DECISION DELEGATED TO HEAD OF PLANNING

Application No:	H06-0839-24	Applicant:	Mr J Rooney
Proposal:	Details of foul & surface water drainage, existing & proposed site levels & flood warning & evacuation plan (Conditions 5(i), 6(i) & 8(i), of H06-0532-23)		
Location:	The Orchards Blazegate Gedney		
Terminal Date:	29th November 2024

This proposal seeks to discharge Conditions 5(i), 6(i) and 8(i), of planning approval H06-0532-23, relating to details of foul & surface water drainage, existing & proposed site levels & flood warning & evacuation plan.

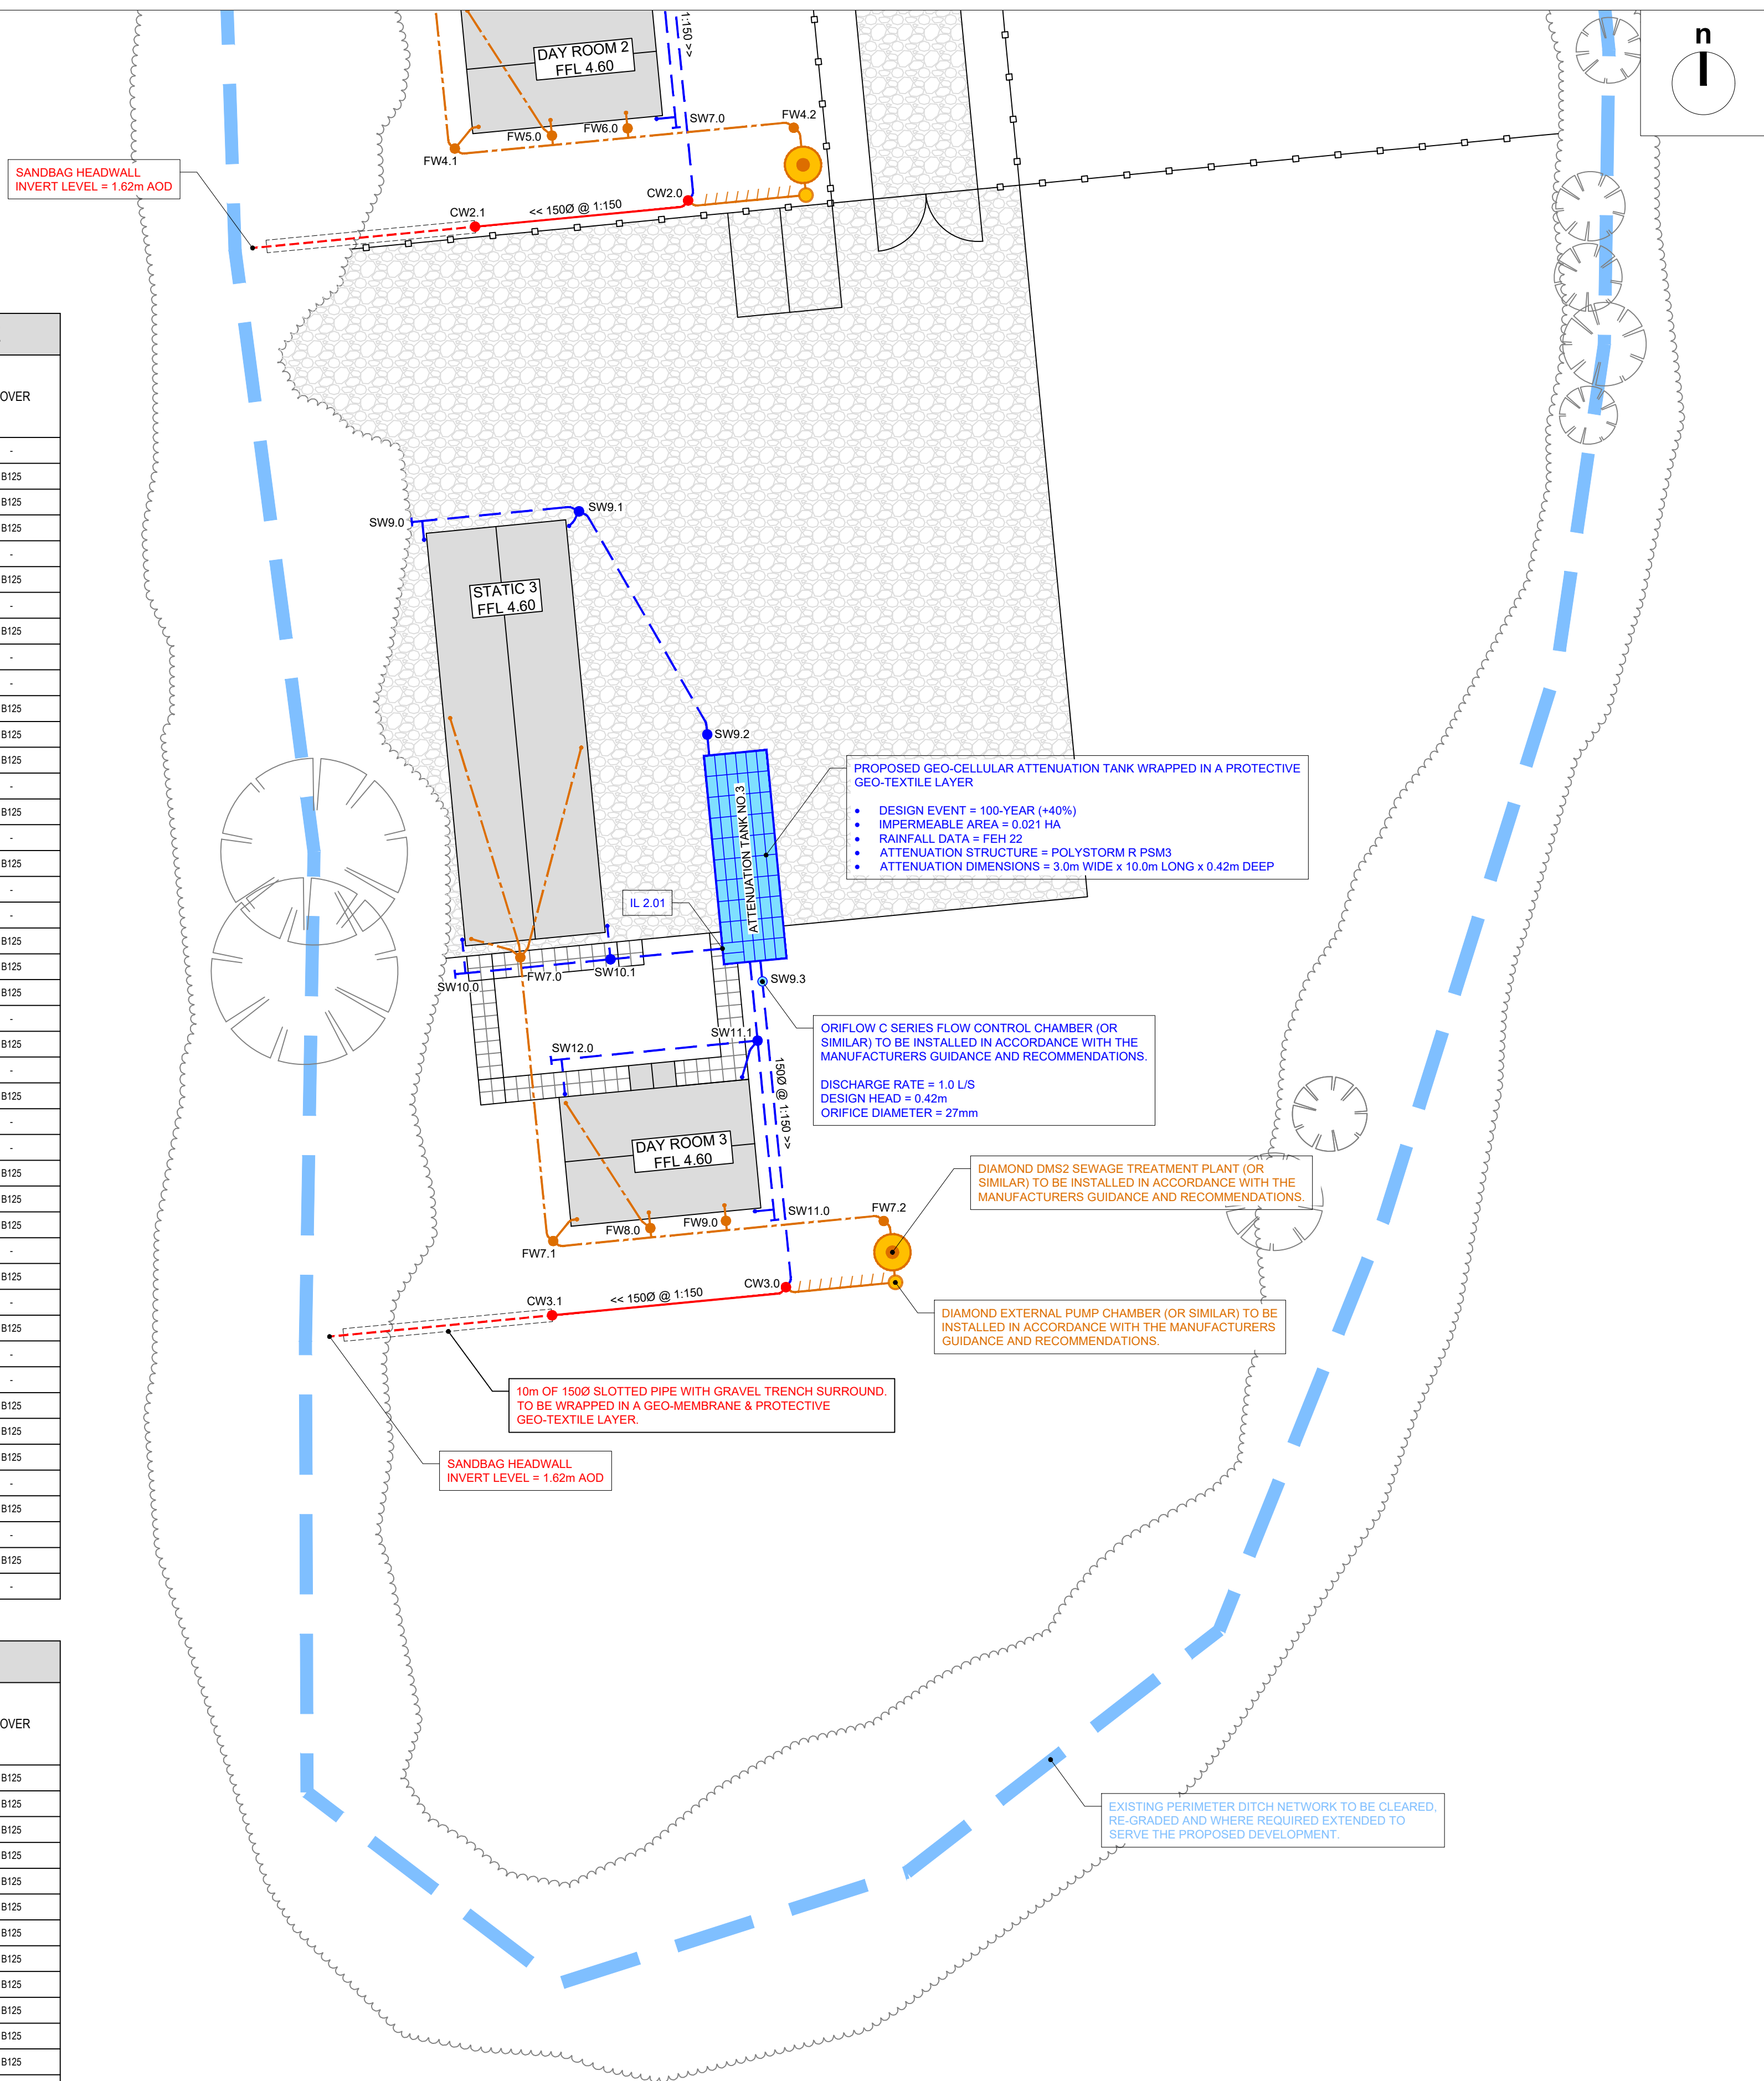
The applicant proposes to discharge surface water to a watercourse at a combined rate of 5 l/s via an individual outfall for each plot (1l/s per plot). This is significantly in excess of greenfield rate, however I note that the proposed discharge rate from each outfall is to reduce the risk of blockages in each system, the separate outfalls having been proposed in response to the site's shape and topography that do not support the use of a single gravity outfall.

The discharge of surface water to the watercourses will require consent under Byelaw 3. Please note that we recommend that any discharge is in line with the Non-Statutory technical standards for sustainable drainage systems (SuDS), therefore the Board is unlikely to grant consent for discharges in excess of greenfield rate. A surface water development contribution is likely to be payable as a condition of any consent granted under Byelaw 3 in line with the WMA's Development Control Charges and Fees.

The applicant has indicated that they wish to discharge treated foul water to a watercourse following treatment using package treatment plants on each plot. This proposal will require consent under Byelaw 3.

The Board recommends that adequate space (3-5 metres) is left flat and free from obstruction adjacent to the riparian watercourse in order to enable maintenance by future riparian owners or a designated maintenance company/contractor.

The applicant proposes to discharge surface water to a watercourse at a combined rate of 5 l/s via an individual outfall for each plot (1l/s per plot). South Holland Drainage Board stated that this is significantly in excess of greenfield rate, however the proposed discharge rate from each outfall is to reduce the risk of blockages in each system, the separate outfalls having been proposed in response to the site's shape and topography that do not support the use of a single gravity outfall.

It should be noted that, should the proposed disposal of surface water will NOT be suitable, then the applicant will need to provide details of an alternative scheme to the Local Planning Authority. Discharge to any watercourse will require the prior written consent of the Board.

The applicant has indicated that they wish to discharge treated foul water to a watercourse following treatment using package treatment plants on each plot. Both the Environment Agency and South Holland Internal Drainage Board have raised no objections given the distance from the site to the main public foul sewer.
